Portishead Branch Line (MetroWest Phase 1)

9.29 ExA.CAS.D4.V1 – Applicant's response to Additional Submission of Mr Stuart Tarr (AS-053)

THE PORTISHEAD BRANCH LINE (METROWEST PHASE 1) ORDER
Applicant's Responses to Mr Tarr's Representations Submitted for ISH 2 and 3 (AS-053)

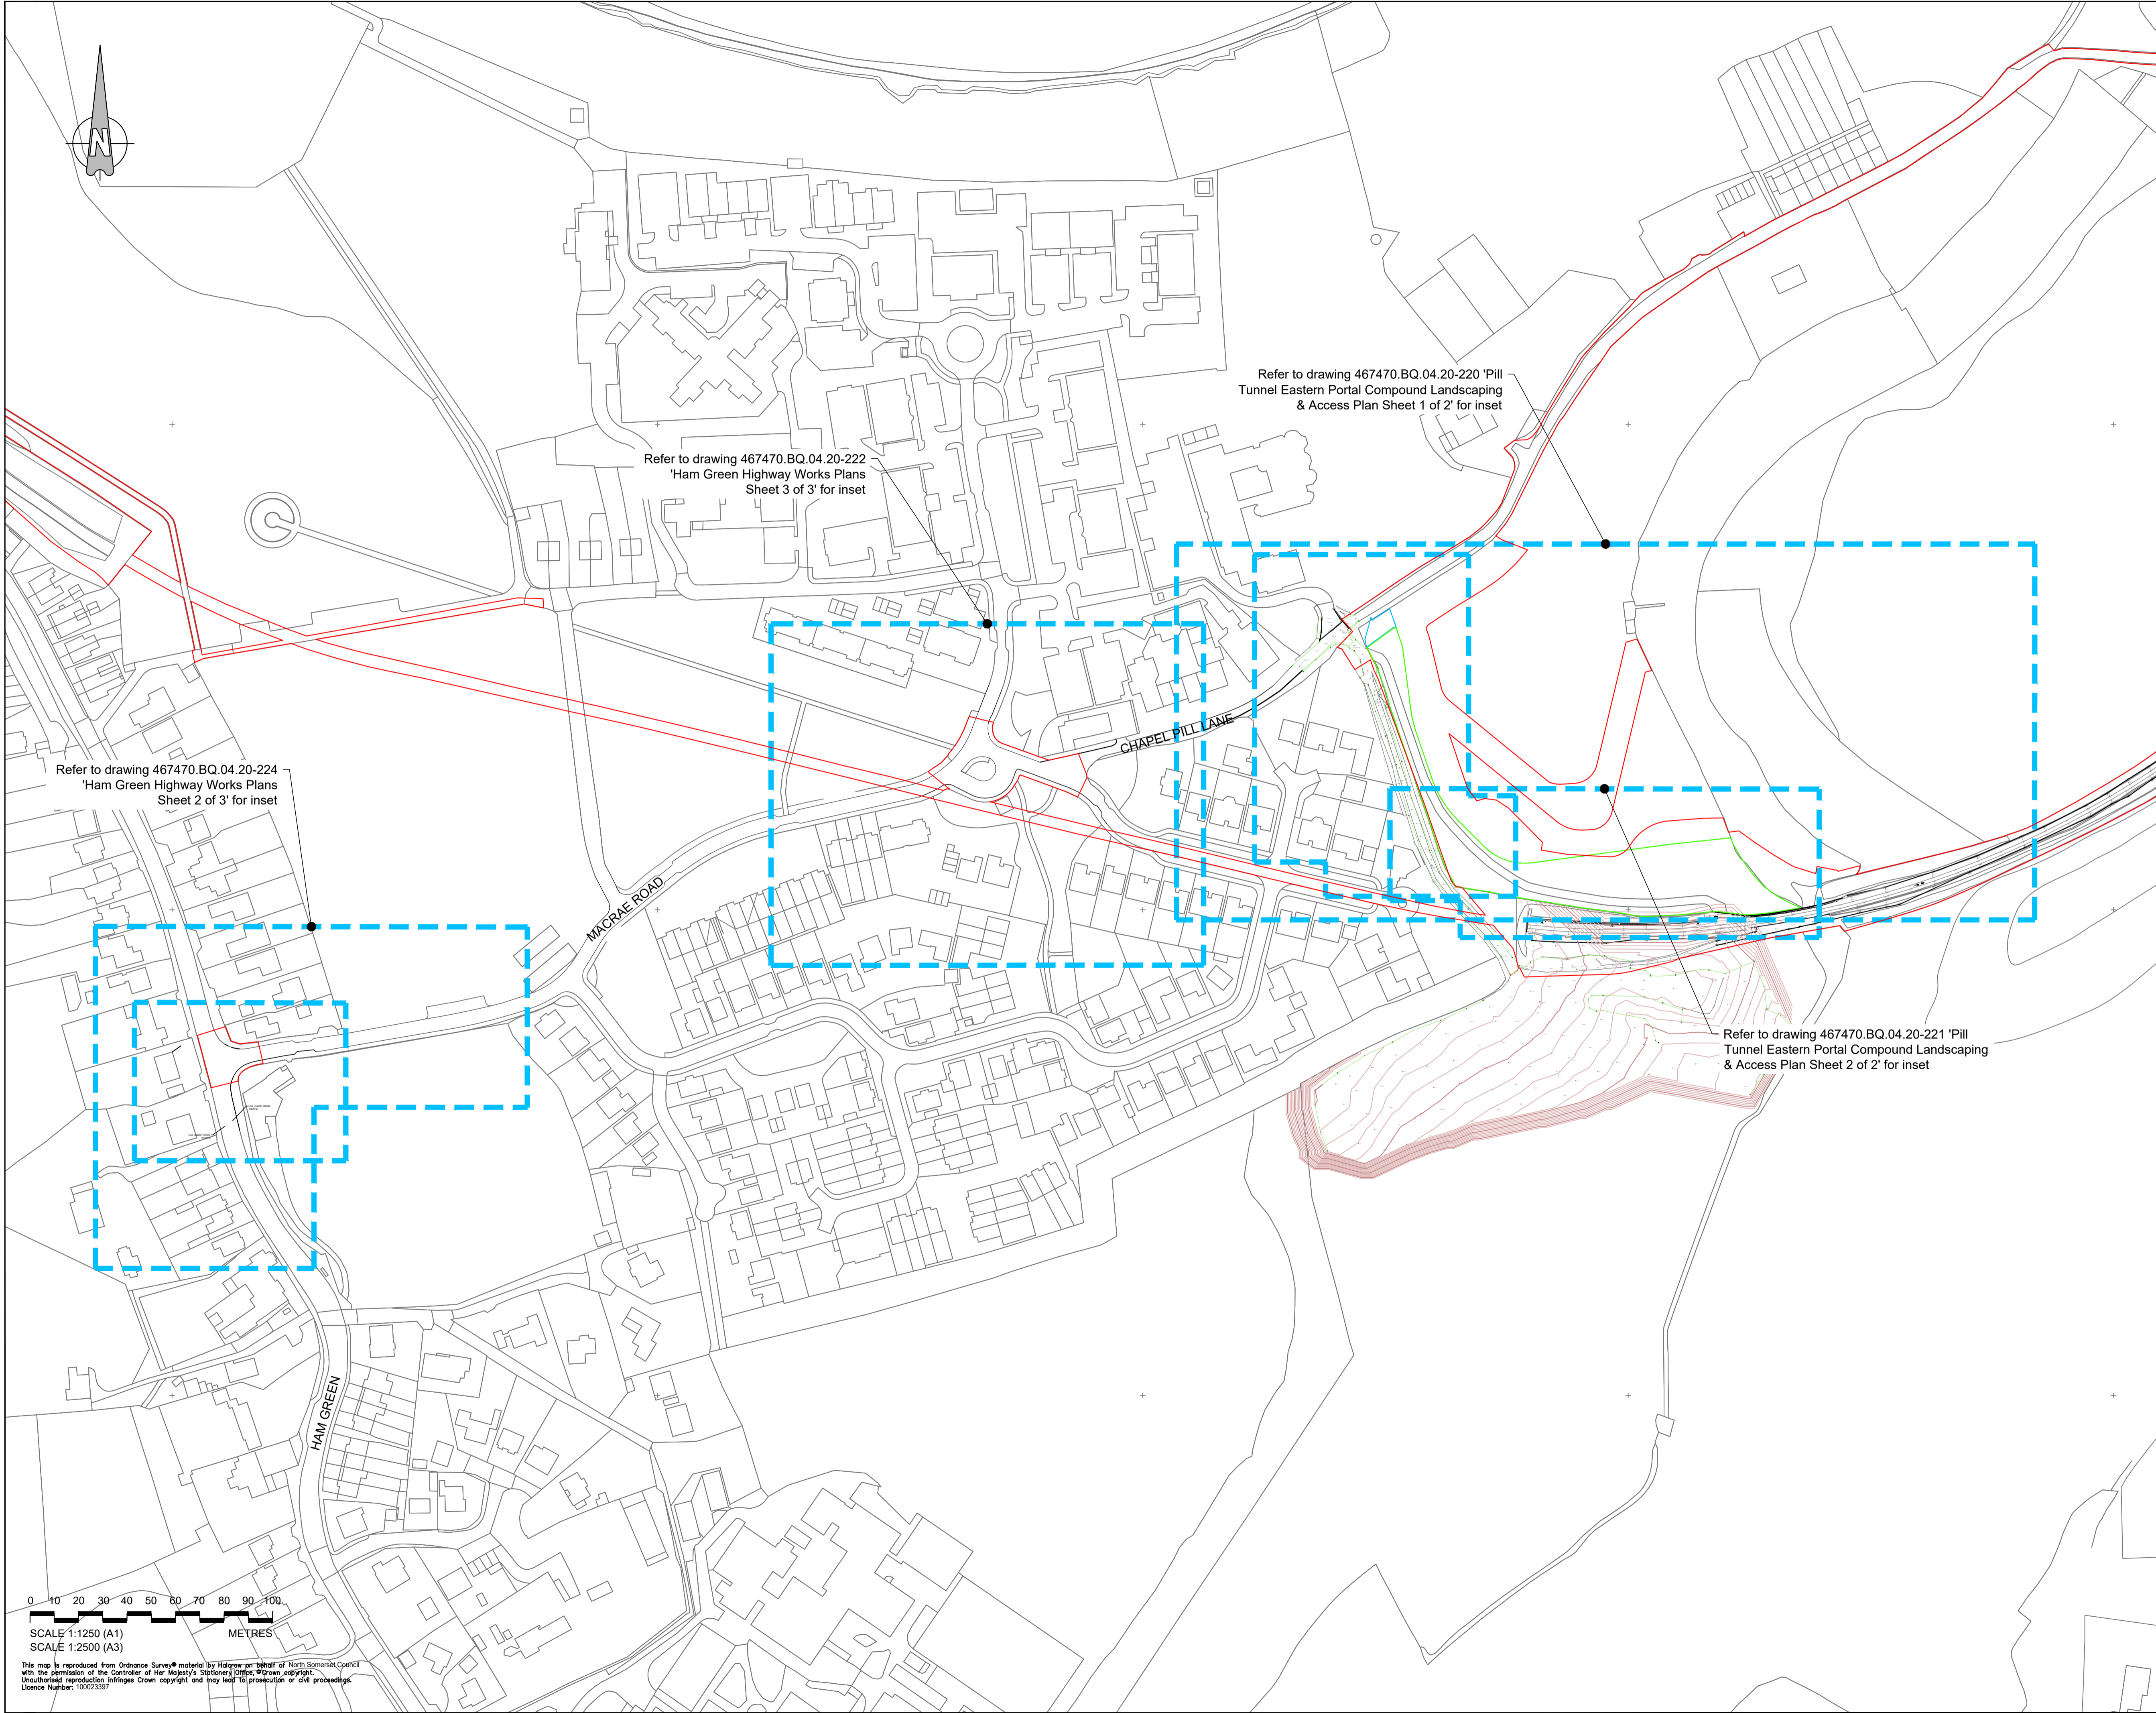
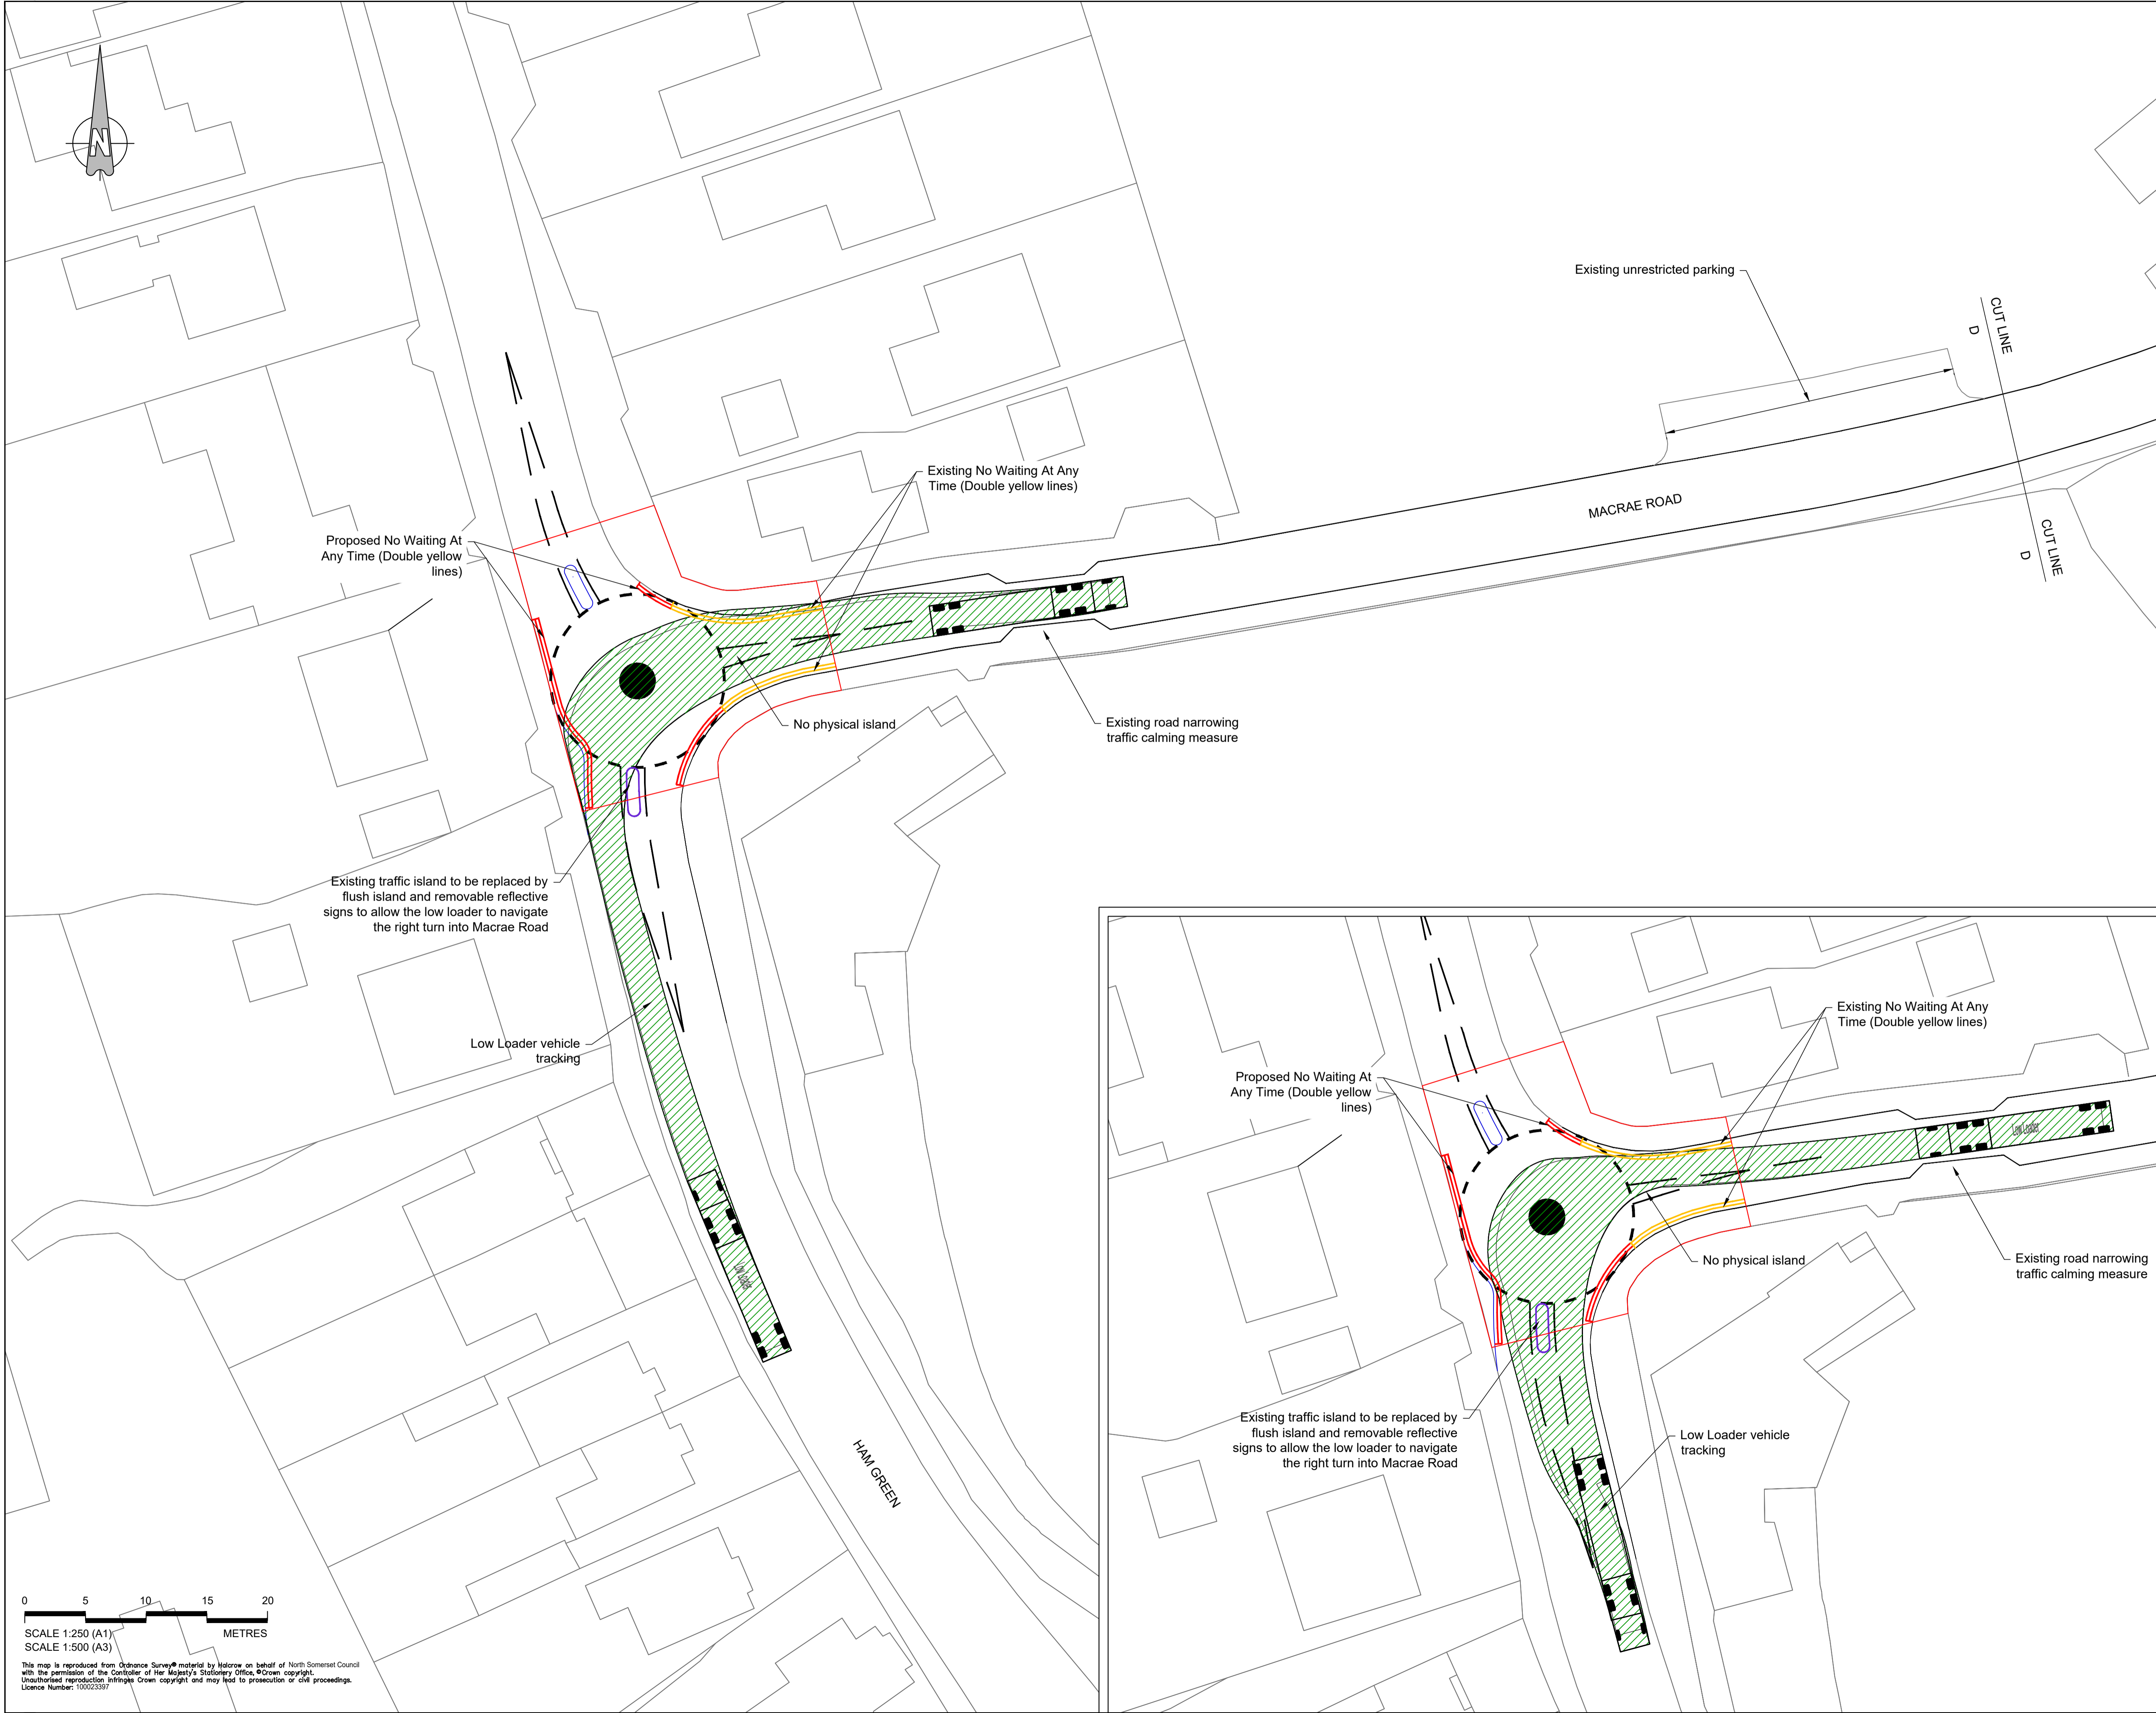
10.	<p>Hearing 2: Construction Practices and Related Matters</p> <p>3.1 Grasscrete is being used for the junction at Chapel Pill Lane so why can this not be used for the track/access road? Why does the access need to be a permanent road surface, especially as</p>	<p>3.1 The area of 'grasscrete' (used here as a generic term to describe a reinforced grass surface that allows vehicles to track over the surface) at the junction is to allow for a low loader vehicle to manoeuvre onto the access track to the compound whilst maintaining the appearance of a grass verge. See APP-040 / 2.45 - 2.46 - Ham Green Highway Works Plans and Pill Tunnel Eastern</p>

Ref.	Mr Tarr's Question	Applicant's response
	<p>the previous access track since dismantled was able to accommodate heavy goods vehicle (HGV) movements with a temporary surface for the repair and upgrade works to the Pill Tunnel when re-establishing the rail freight line? Moreover, this would result in a more sustainable solution to protecting the openness of the Green Belt, its visual amenity, and protecting the bio-diversity of lake?</p> <p>3.2 Secondly, how often will the track be used for essential maintenance and drainage at the Pill Tunnel, for track inspections etc, and what vehicles will be required? Presumably, if there are frequent HGV movements, it would be inappropriate on highways and pedestrian safety grounds and would conflict with Network Rail's own safety regulations to share the access with the proposed social housing development referenced in the Neighbourhood Plan and which, for that reason, should be refused (see also the Applicant's response to Representations at the Open Floor Hearing Held on 19 October 2020)?</p>	<p>Portal Compound, Landscaping and Access Plan Drawing 467470.BQ.04.20-221, which shows the manoeuvre being catered for.</p> <p>'Grasscrete' is not considered appropriate on the access track as the track is also required for emergency access to the tunnel portal. Owing to the relatively steep slopes, a tarmac surface finish is considered appropriate to ensure vehicles do not skid on a grassed surface.</p> <p>The width of the access track has been minimised to 'single' lane with a passing place, and screened with a 2m wide hedge and trees.</p> <p>The temporary construction compound in this location is primarily to enable the construction of the access itself.</p> <p>3.2 Usage will be for inspection maintenance and emergencies. There will be visual track inspections and checking of the silt buster and pump for Pill Tunnel. These inspections could be weekly and 2-3 vehicles could be expected. Maintenance access will mainly be by vans or pickups. Larger vans/small trucks will only be required when works are planned that require RRV's or materials. Larger vans/small trucks should be expected circa two or three times a year.</p> <p>The adequacy of access for the housing development will be for the LPA to consider at the appropriate time. The Applicant for this Order is not in a position to comment on the proposals for access for that proposal.</p>
